Your Ref: OWPC20096
Our Ref: R/190/18/PL 31-07-2018
Please ask for:
Mrs A Gardner

Demolition of 1 No. existing house & grounds & erection of 2 No. new detached dwellings. This application may affect the character & appearance of the Station Road, East Preston Conservation Area.

St Marys Close Hurst Road Rustington

Thank you for your internet representation made on 6th October 2018 which has been recorded as '**an objection**' with the comments as follows:

Drawing Title:
ADDITIONAL DWELLINGS
BLOCK/ SITE PLAN

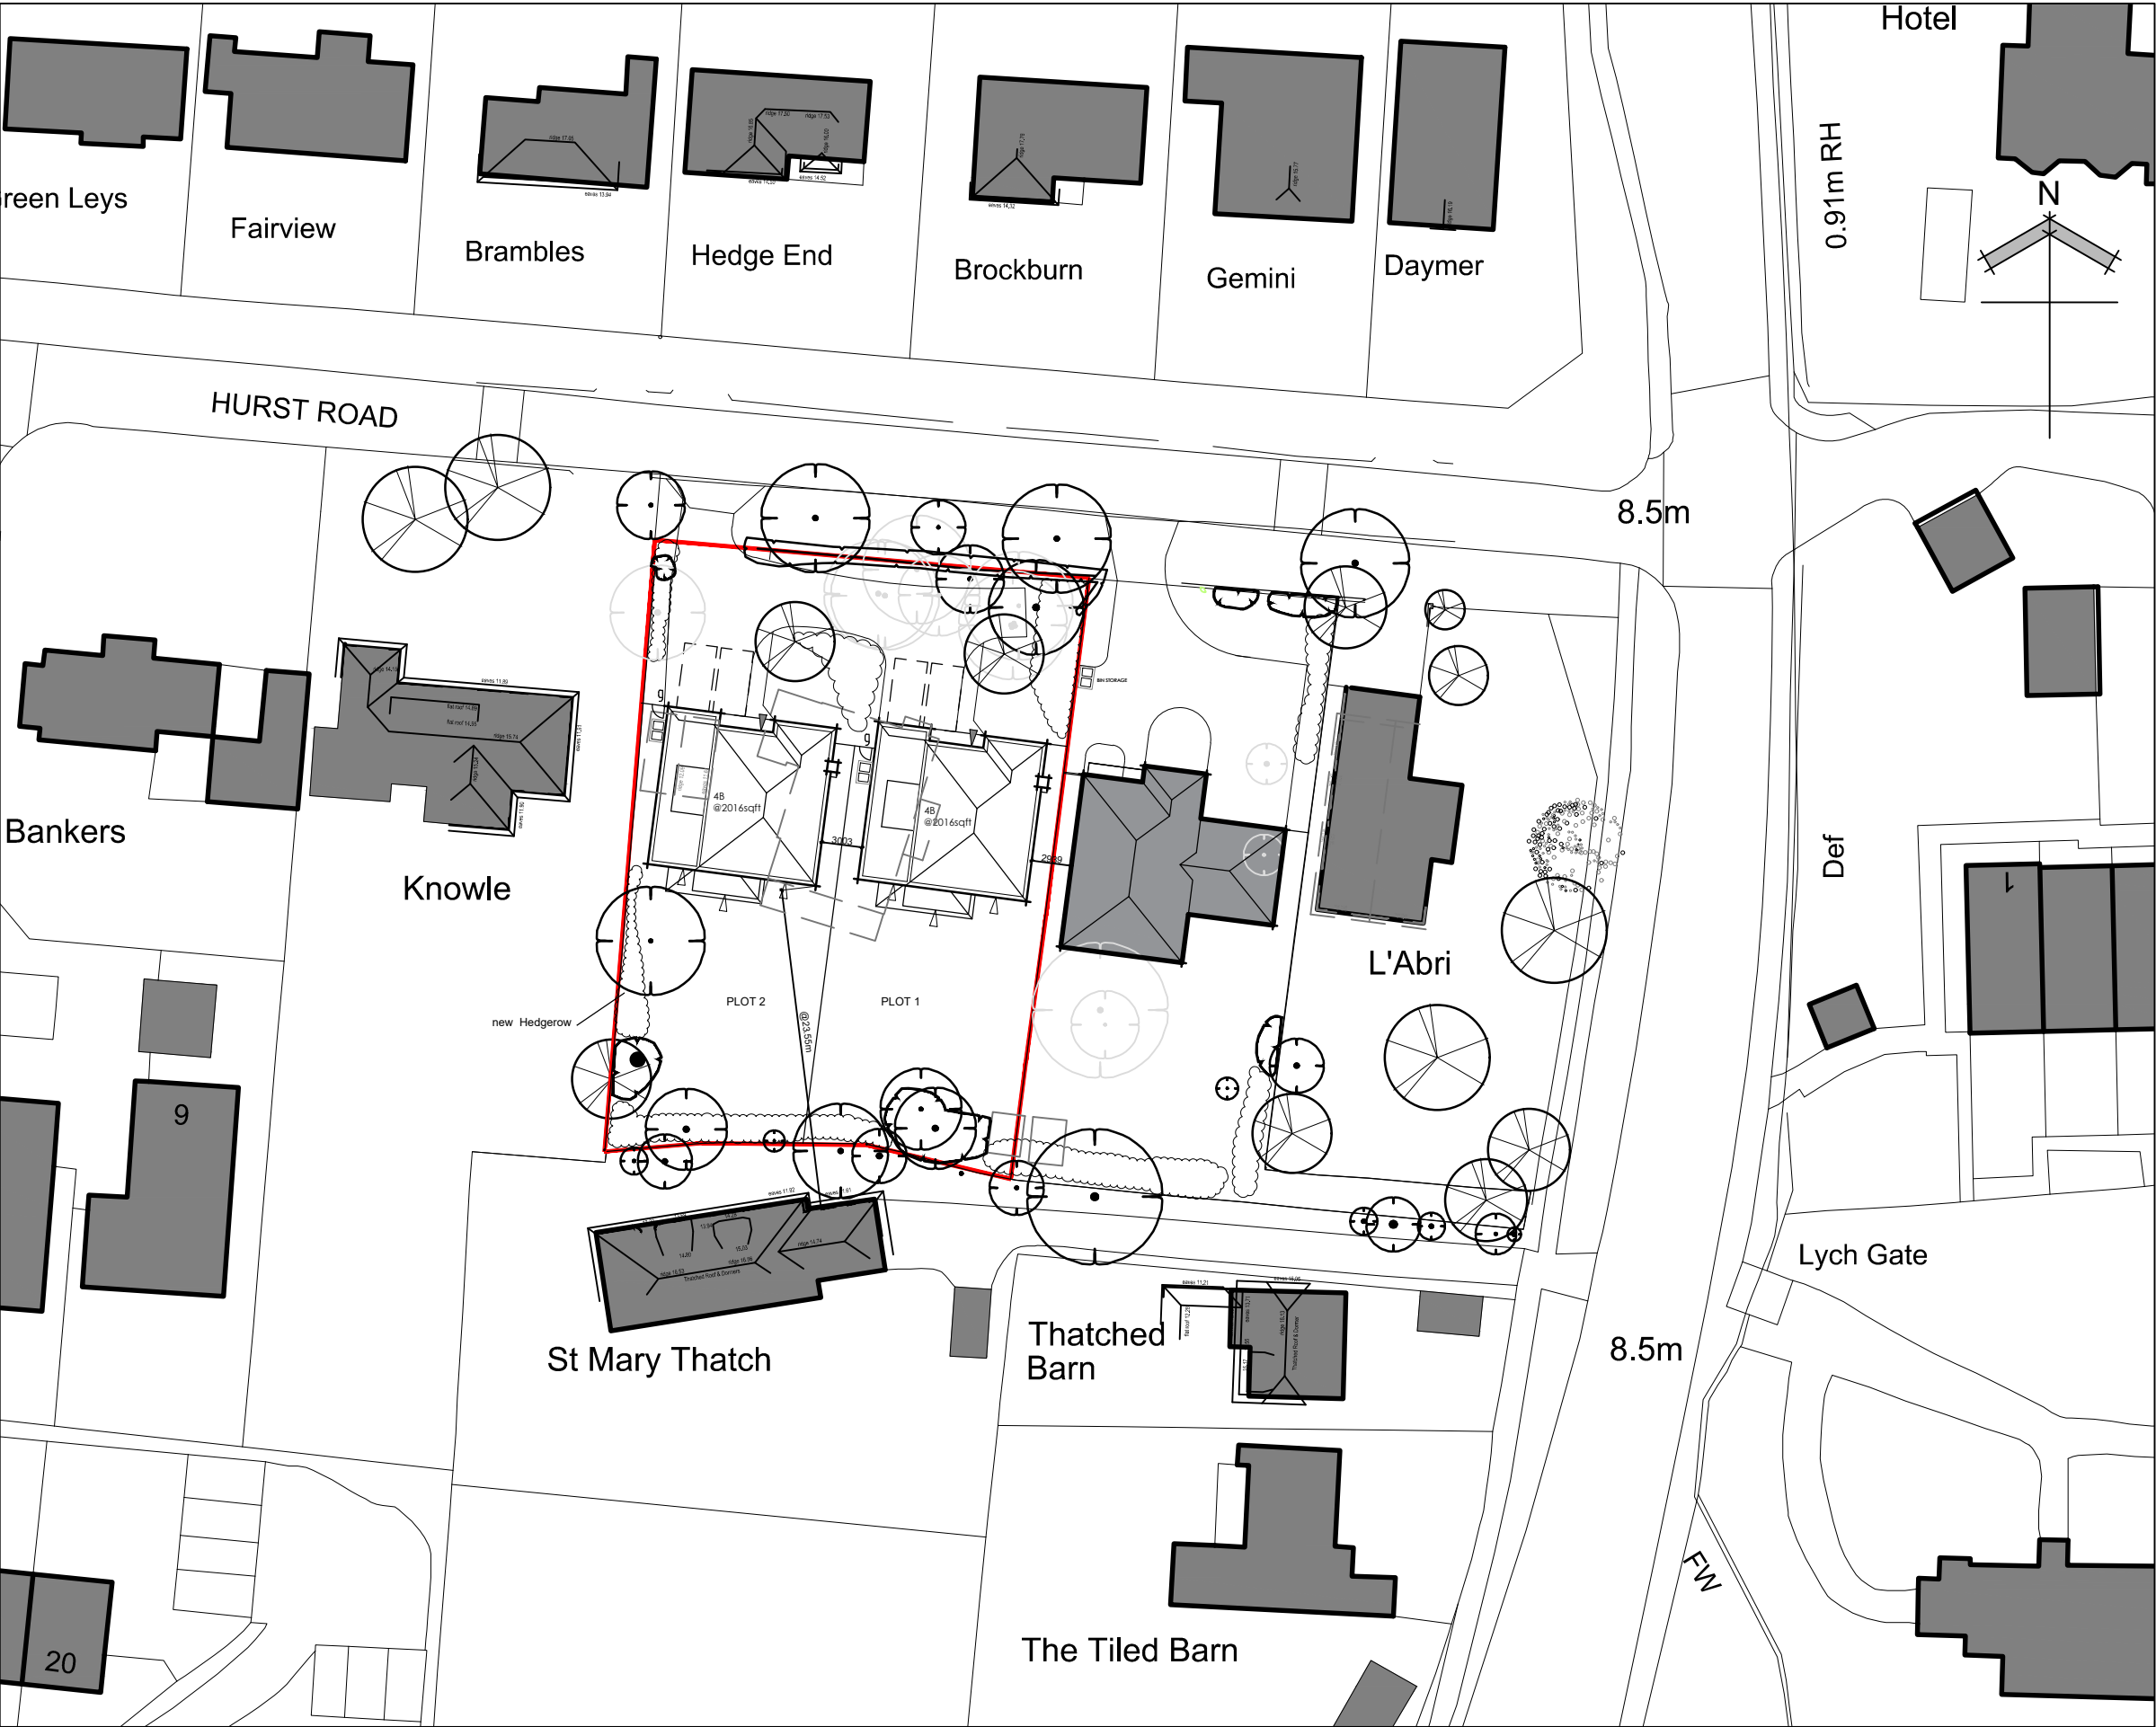
Quite separate from my objection, I notice that the boundary between the eastern and western plots, application references R/202/18/PL and R/190/18/PL respectively, are

inconsistent with one another and, if not resolved, would result in a small piece of land being owned by more than one occupier. I guess this is an error in one of the developer's block plan diagrams.

Drawing Title:
ADDITIONAL DWELLING
PLOTS 1 & 2
ELEVATIONS

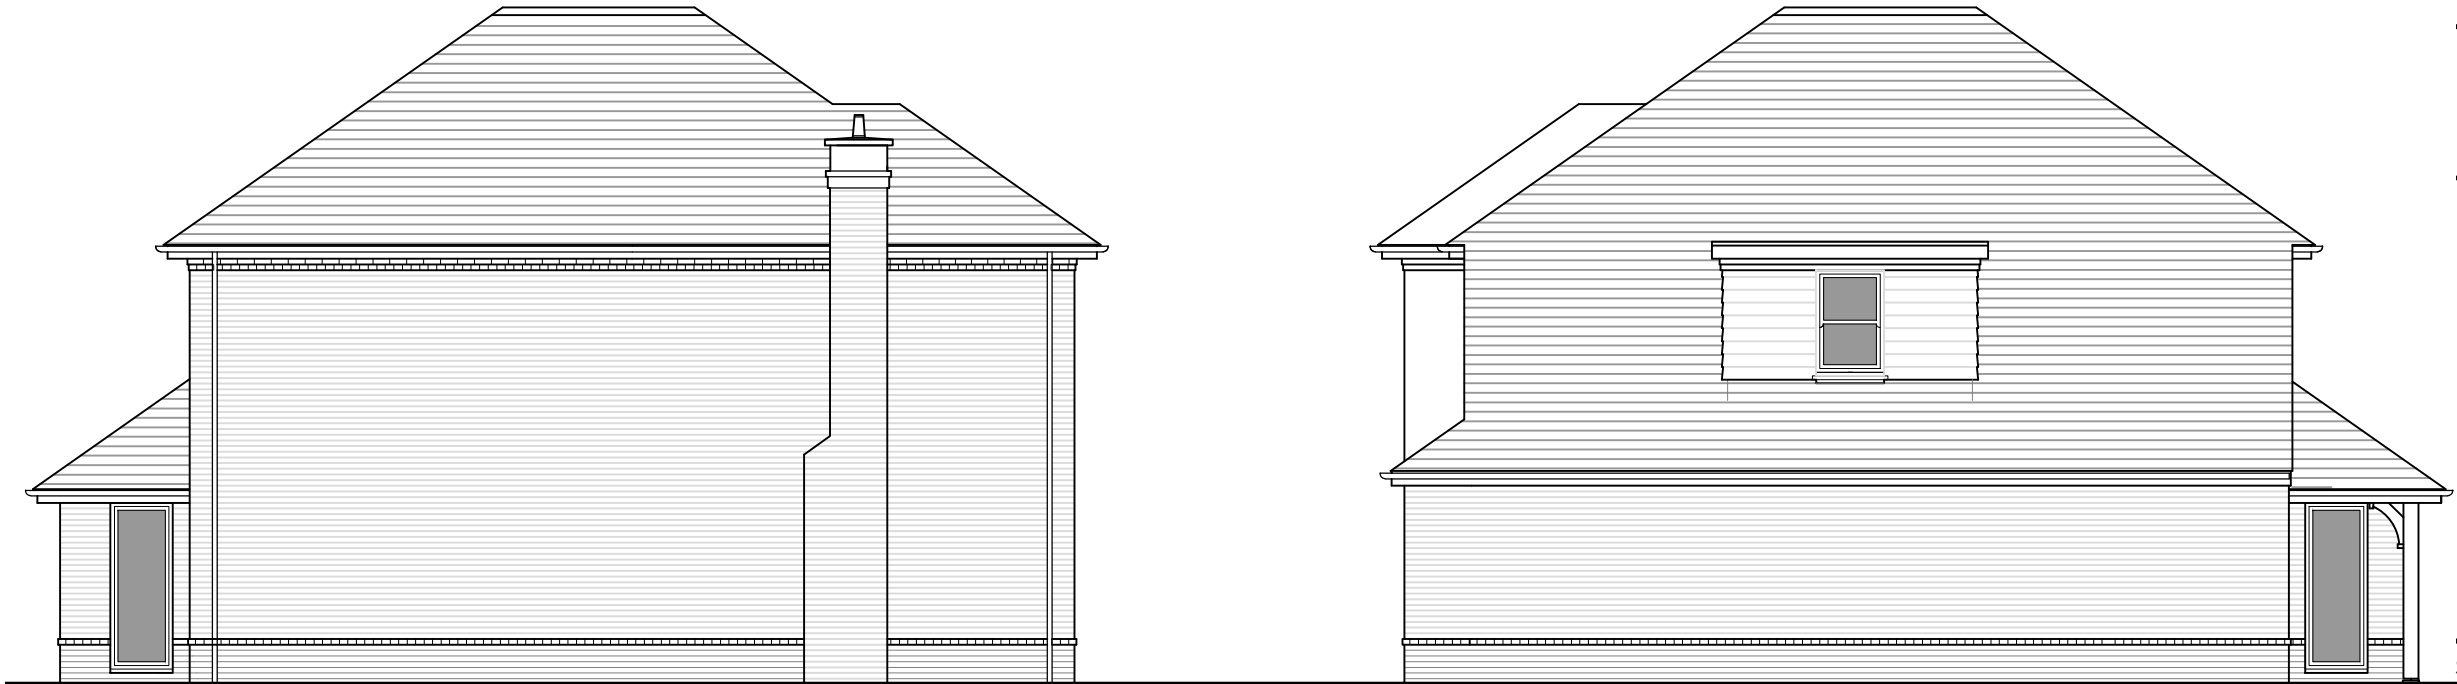
All the existing houses in Hurst Road are of a unique design. This is one of the major characteristics of the road and gives the whole road a unique appeal. This application is for 2 houses with identical design and orientation with only a 3 meter separation distance. I cannot object to the density of the proposal as it is broadly in line with the houses opposite but I submit that it will detract from the character of the road to have 2 identical houses sat next to each other with only a small separation distance between them.

In paragraph Site Description & Background of the Covering Letter which accompanies the application, the developer recognises the unique designs of the existing houses, saying "... Hurst Road, a residential street comprising properties of varying age, design and scale". However, in the paragraph Conclusions he says "The scheme has incorporated all the key characteristics of the area and will have a positive impact and appearance of the area in which dwellings and architectural design vary considerably." Although he recognises the variety of houses in the road he has chosen to ignore this in his plans but still insists that his scheme "incorporates all the key aspects of the area" when it clearly doesn't. I submit that cosmetic variations, eg using different roof tiles and paint colours, will not make his 2 identical designs 'unique' when compared to the truly uniquely designed houses found in the rest of the road.
